**RE: LACUEVA CORONA SUBDIVISION (C19-D6). GRADING AND DRAINAGE PLAN
FOR FINAL PLAT APPROVAL. ENGINEER'S STAMP DATED MARCH 6, 1997.**

***RE: Grading and Drainage Certification for La Cueva Corona Subdivision (C19/D6)
Submitted for Release of Financial Guarantees, Engineer's Stamp Dated 1/5/99.***

RE: LA CUEVA CORONA SUBDIVISION (C19-D6). UPDATED GRADING AND DRAINAGE PLAN FOR FINAL PLAT, GRADING, AND PAVING PERMIT APPROVAL. ENGINEER'S STAMP DATED NOVEMBER 21, 1997.

**RE: LACUEVA CORONA SUBDIVISION (C19-D6). GRADING AND DRAINAGE PLAN FOR
PRELIMINARY PLAT, FINAL PLAT, AND GRADING PERMIT APPROVAL. ENGINEER'S
STAMP DATED JANUARY 17, 1997.**

GRADING & DRAINAGE PLAN HYDRAULIC CALCULATIONS

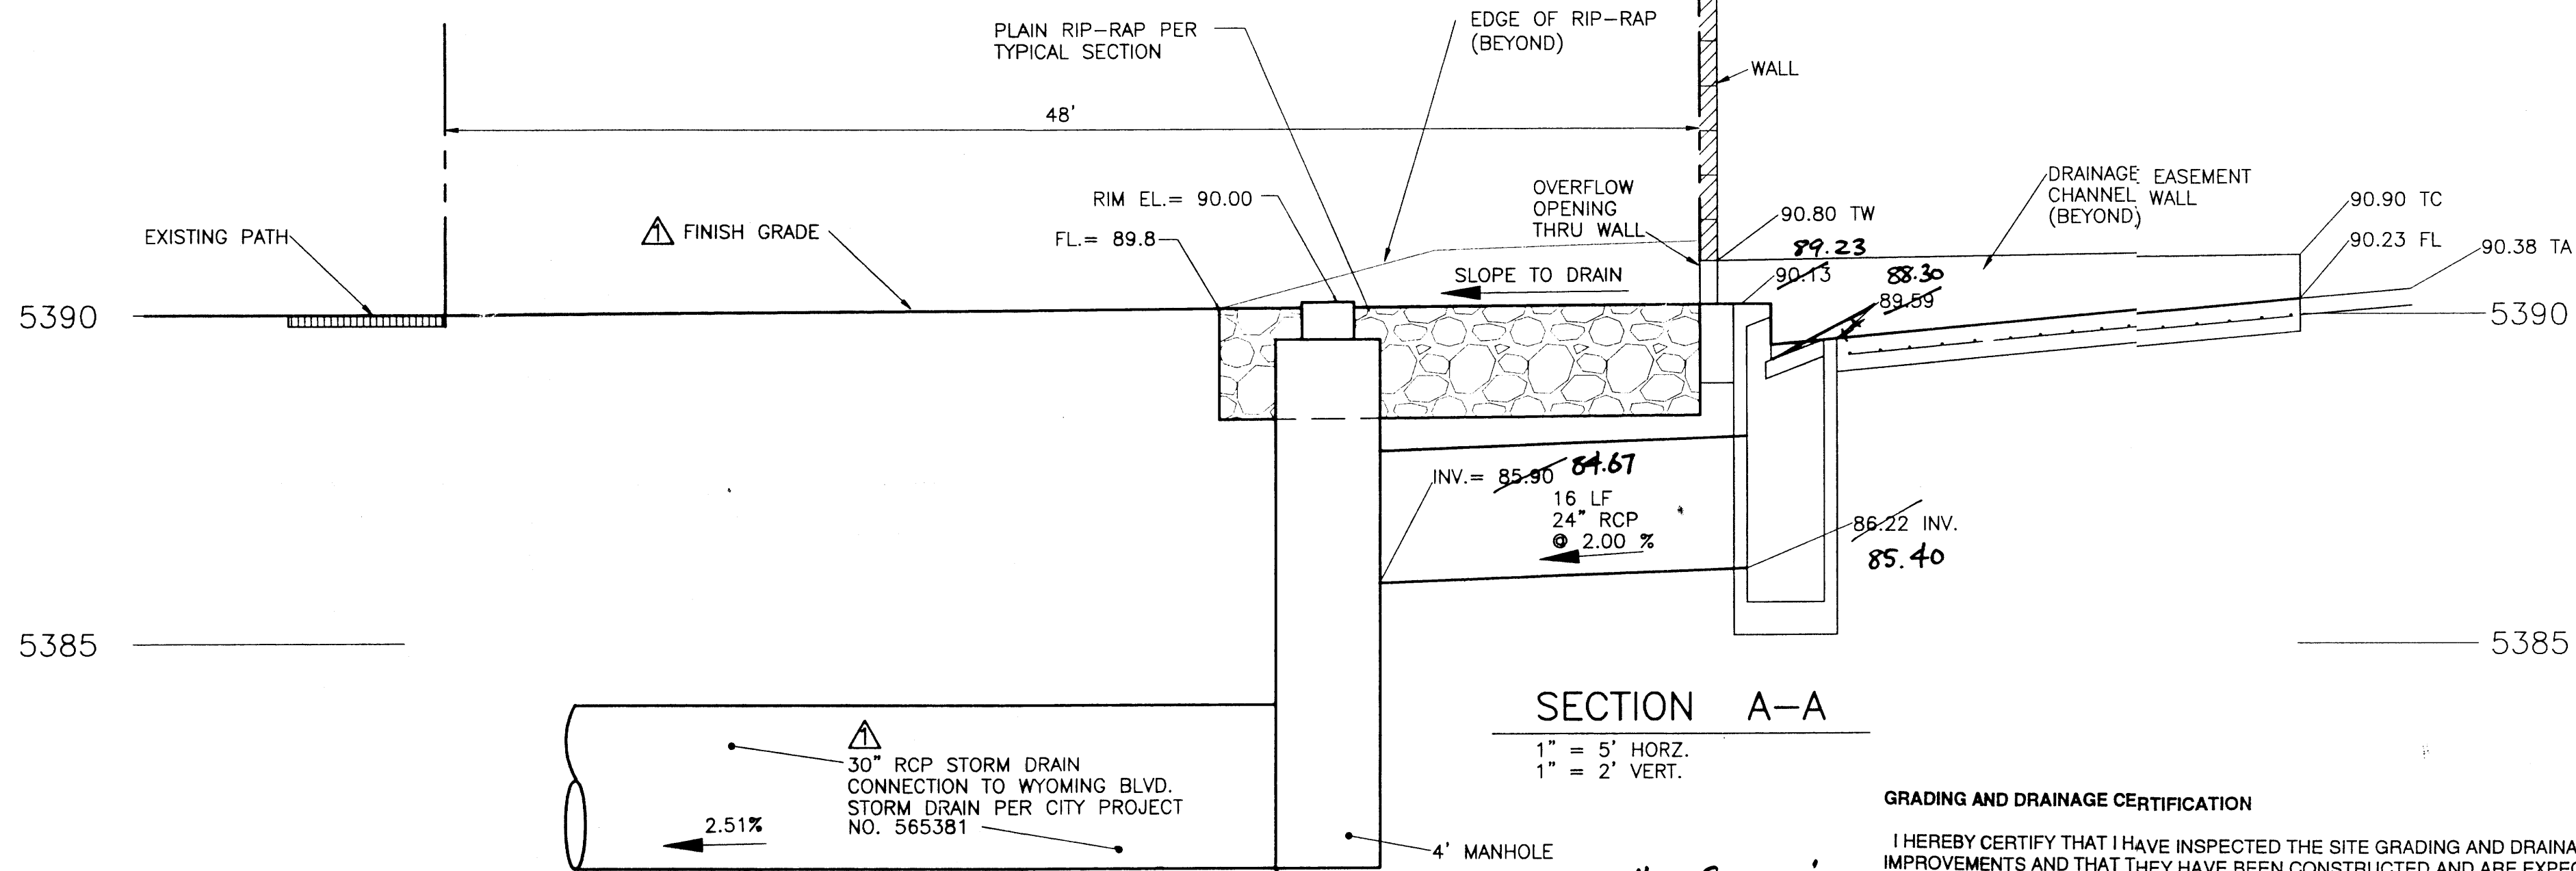
1. Under the paragraph titled "METHOD," please delete the word "Conceptual."
2. Prior to final plat approval, a maintenance agreement for the temporary retention pond will have to be resolved.
3. You will need to fence the 3-foot retention pond. Retention ponds greater than 18-inches must be fenced.
4. Show finish pad elevation to mean sea level.
5. On section A-A, show future 24-inch RCP from pond to Wyoming. The details can be cleared up at DRC, however, I'd like to see the general idea on the referenced section.
6. Provide an overflow for the double "C" inlet.
